TRANSPORT FOR LONDON

M25 JUNCTION 28 IMPROVEMENTS – RESPONSE TO RULE 17 LETTERS AT DEADLINE 8

9 JUNE 2021

**Fig 3.1 - HE Indicative alignment of amended Grove Farm egress (Change 8)**

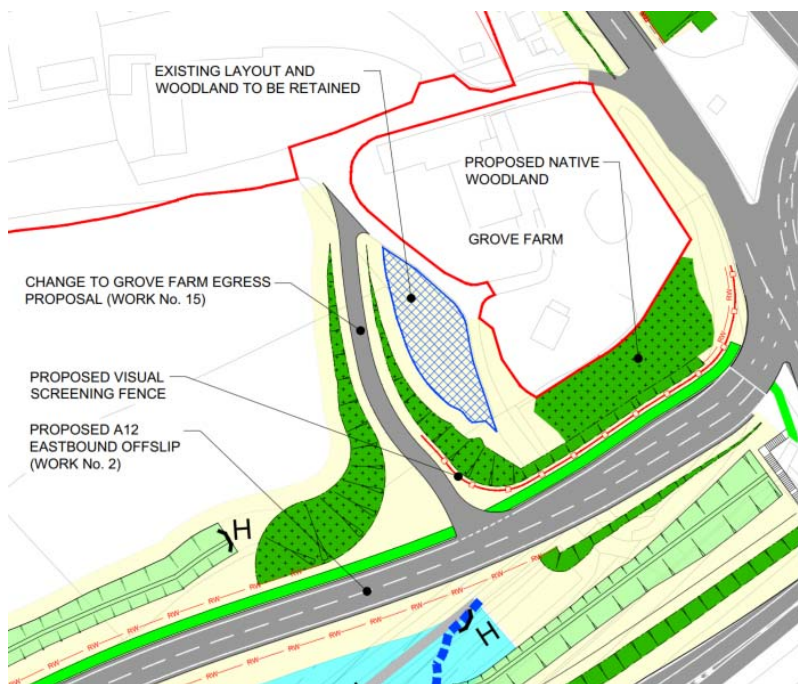
- 2.1.1 The ExA has requested views on whether Change Request 8, a revision to the alignment of the egress from Grove Farm onto the new A12 eastbound off slip road, constitutes a material change to the application, either individually or cumulatively, and whether or not it falls within the scope and assessment of the Environmental Statement.

- 2.1.3 TfL considers that Change Request 8 will have no material impacts on road safety, traffic flows or delays, given that the egress joins the new A12 eastbound off slip is only approximately 25 metres west of the position previously proposed. On this basis TfL's view is that the scope and assessment of the Environmental Statement with regard to transport impacts covers the proposed change.
